From: Contact Centre (CRM) <contact@ribblevalley.gov.uk>
Sent: 12 May 2022 09:05
To: Planning
Subject: Planning Application Comments - 3/2022/0421

Planning Application Reference No.: 3/2022/0421

Address of Development: 21 Paris
Ramsgreave
BLACKBURN
BB1 9BJ

PROPOSED NORTH EAST ELEVATION (FRONT). SCALE 1:100

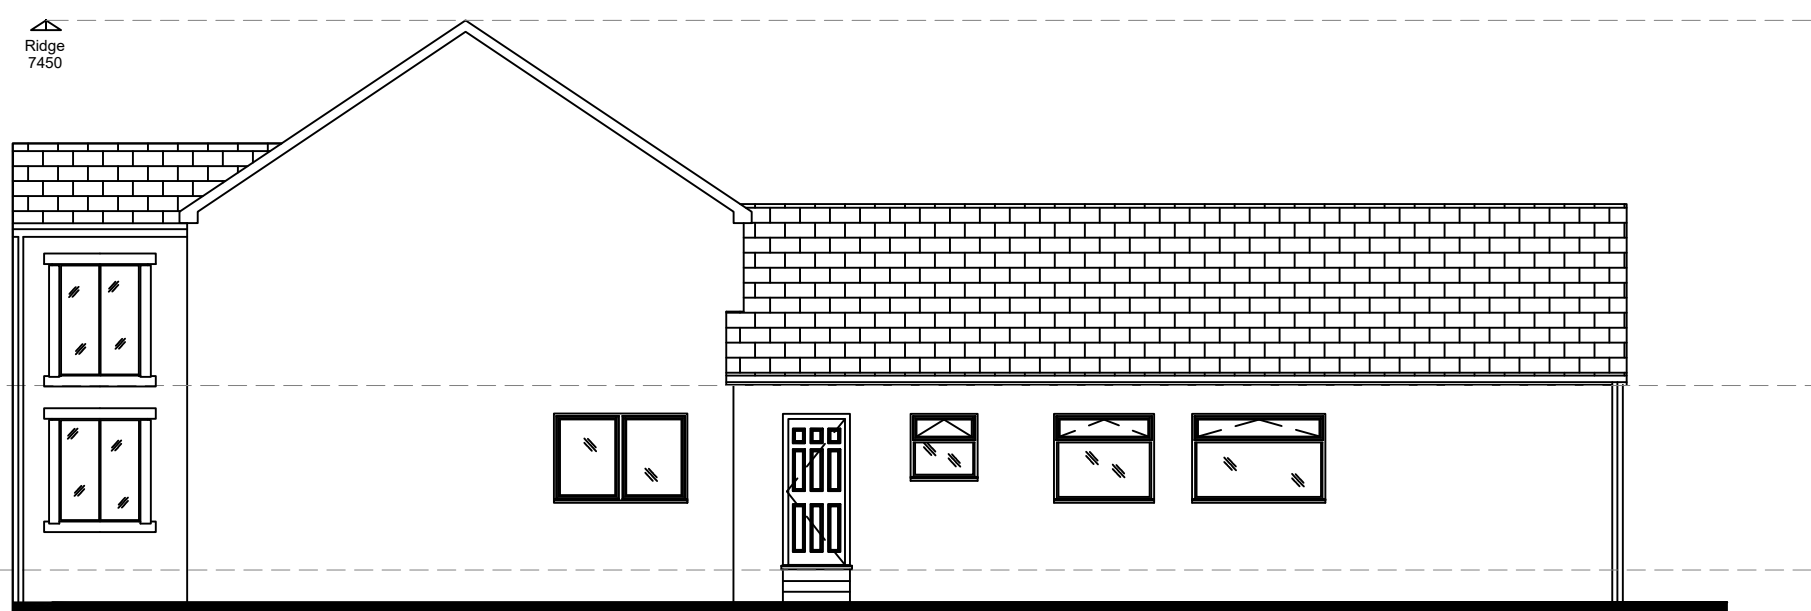
Comments: The changes requested would provide a significant increase in the amount of living and bedroom space in the property. This would be over an above what is already to be a significantly sized property. The design and size is out of keeping with all neighbouring properties and will be of high visibility from Whalley New Road, Walden Road & Parsonage Road. In addition, there would be potential impact on the amount of parking required for the property. In turn this could impact on traffic and parking on what is a narrow road. There is also potential for loss of privacy to adjoining properties from the addition of first floor level "porch" windows to both sides (North & South) of the elevation.
